RE; Residential Development on land to the South of Doncaster Road, Darfield, Barnsley.
In joint application with Keepmoat Homes

Further to your recent email regarding comments from consultees on the above application we write to provide the following information:-

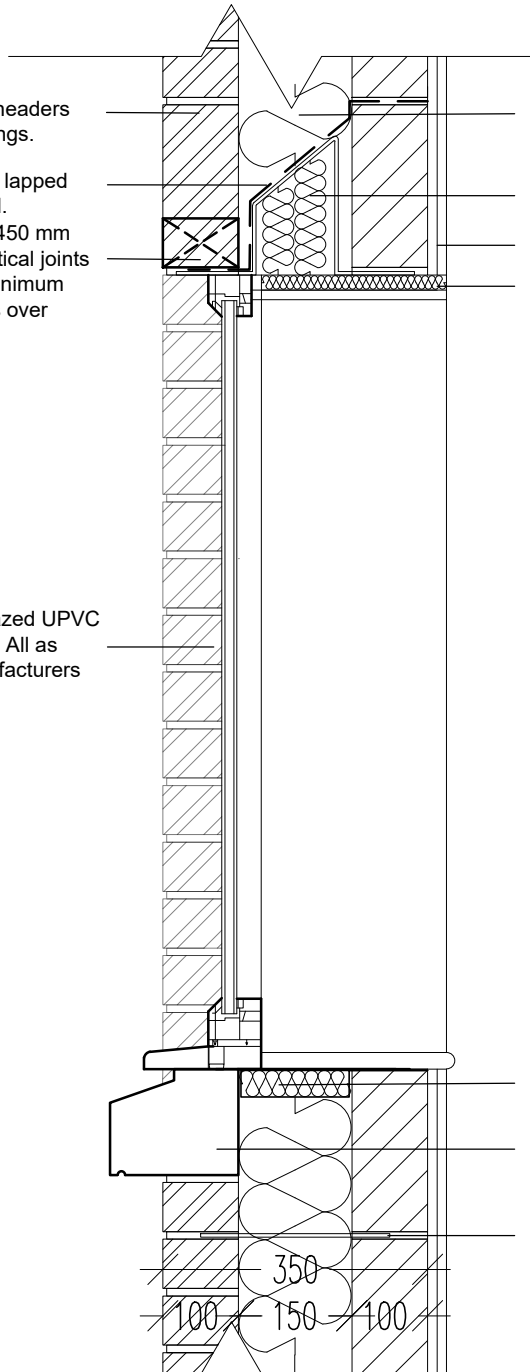
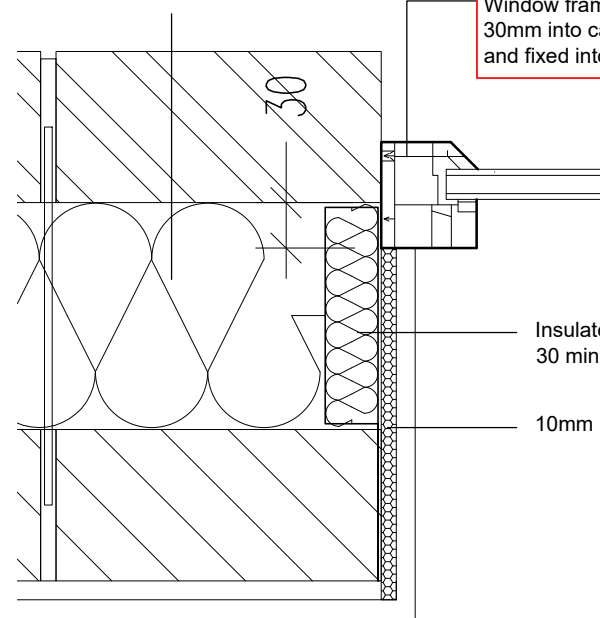
The SPD 'Design of Housing Development' states, (in para 7.11), 'Window and door openings should have sufficient recess in the reveal to give visual articulation. Typical cross sections of windows and doors at 1:5 or 1:20 scale should show a minimum 50mm set back within the reveal.'

As requested, please find attached the following details: -

- *SD_2503_A_ - Render - Window Details - Head & Cill – Plain*
- *SH / ST / 150 - External Door Detail Threshold and Jamb details*
- *SH / ST / 151 - External Window Detail and Jamb details*

These provide typical cross sections of each developer to show compliance in respect of the recess details.
